APPLICANT'S RESPONSE TO INTERESTED PARTIES' DEADLINE 1 SUBMISSIONS NUMBER: 9.12

Cory Decarbonisation Project

PINS Reference: EN010128

DECEMBER 2024

FRONT ELEVATION
SCALE 1:500

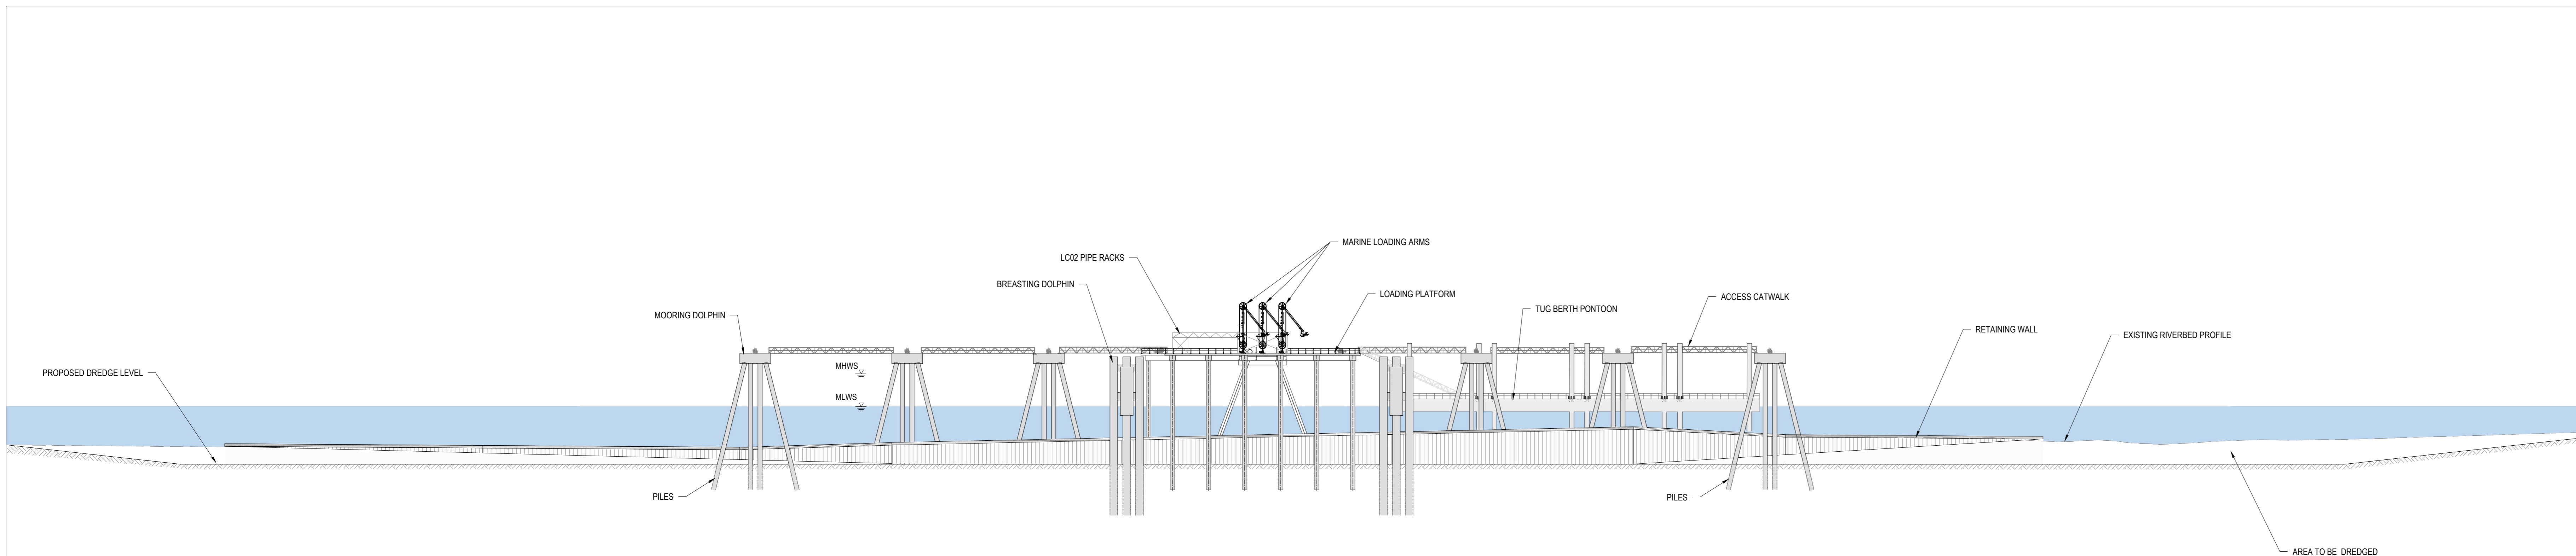
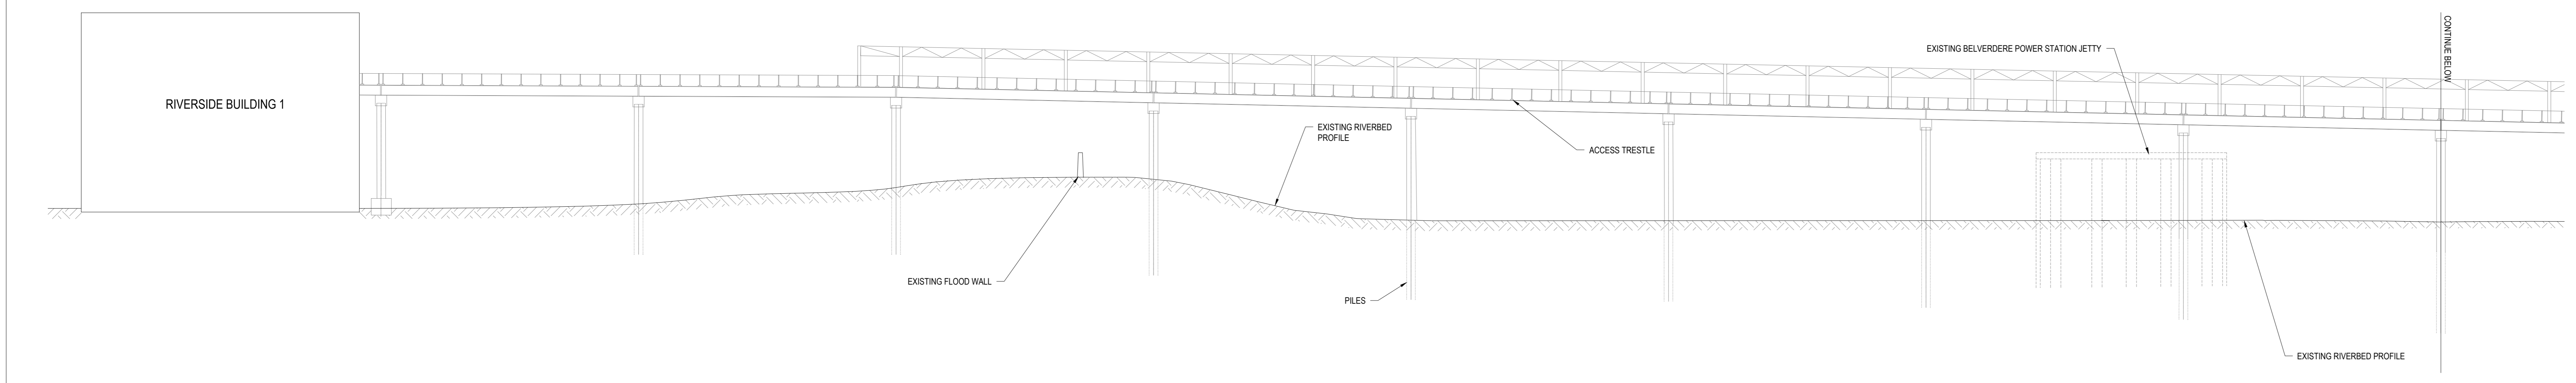
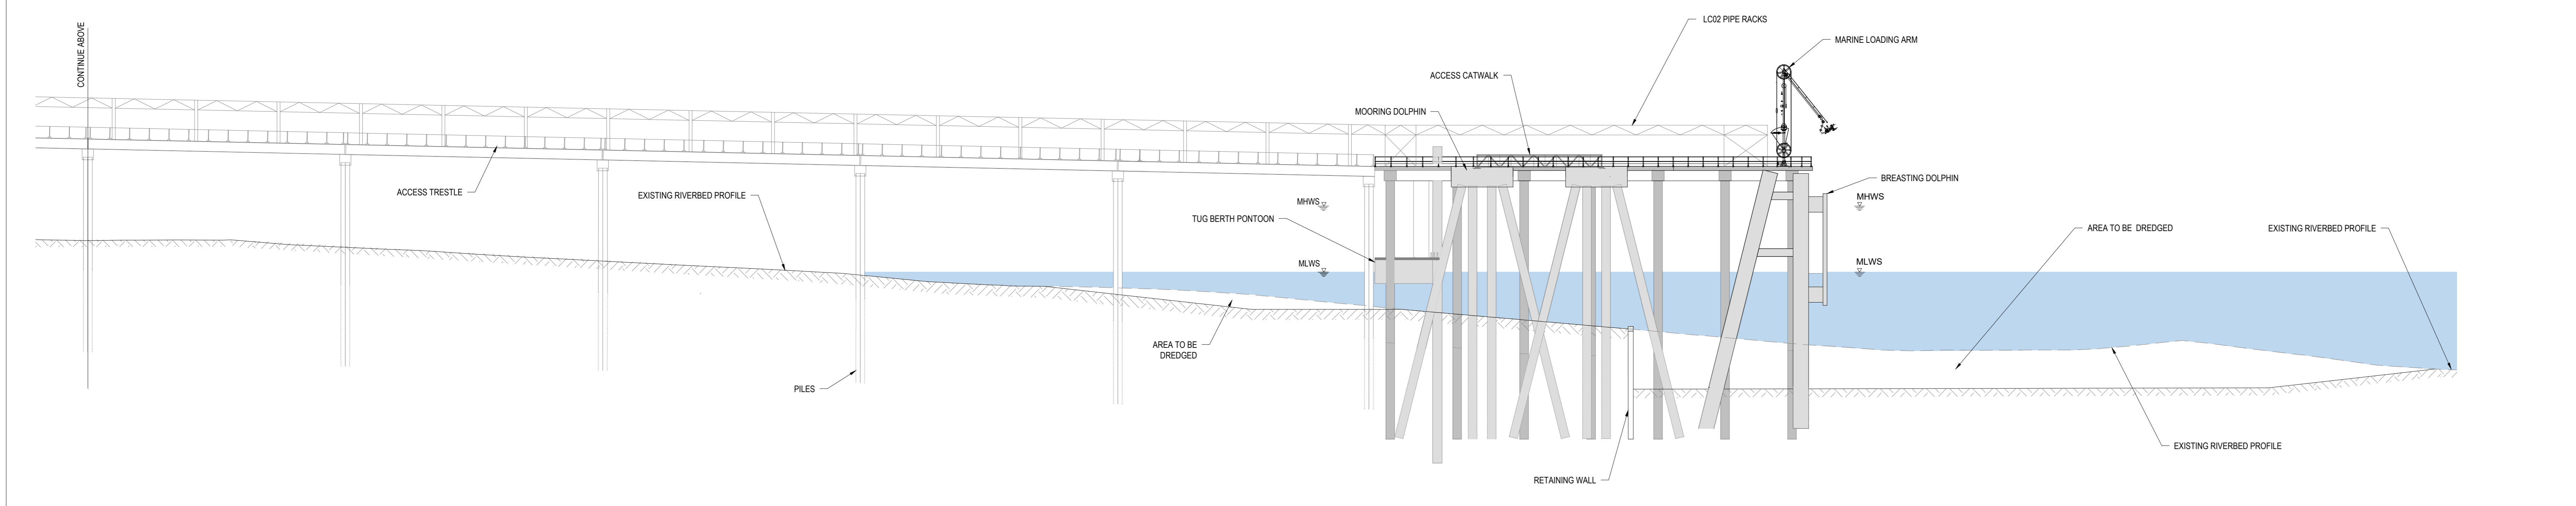
Doc ref	Summary of issue raised	Applicant's response
Order Limits		
<p>REP1-039</p>	<p>(4.2a) "The limits of deviation for Work No. 4C extend into the authorised channel. The Engineering Plans – Proposed Jetty Indicative Drawing [APP-017] shows dredge slopes extending to but not within the authorised channel. This accords with the Applicant's response to the PLA's Relevant Representation [AS-043] where it is stated in table 7-1 that it is the Applicant's intention to tie the dredged pocket to the authorised navigation channel and that their intention is [not] to undertake dredging itself within the authorised channel (although this cannot be completely ruled out at this stage) but the limits of deviation need to allow for any slumping that is associated with it".</p>	<p>As noted in its previous responses, the PLA will retain control of such operations pursuant to its Protective Provisions, and article 8 of the Draft DCO (updated alongside this submission) provides for no fetter on the PLA's activities in the navigation channel.</p>
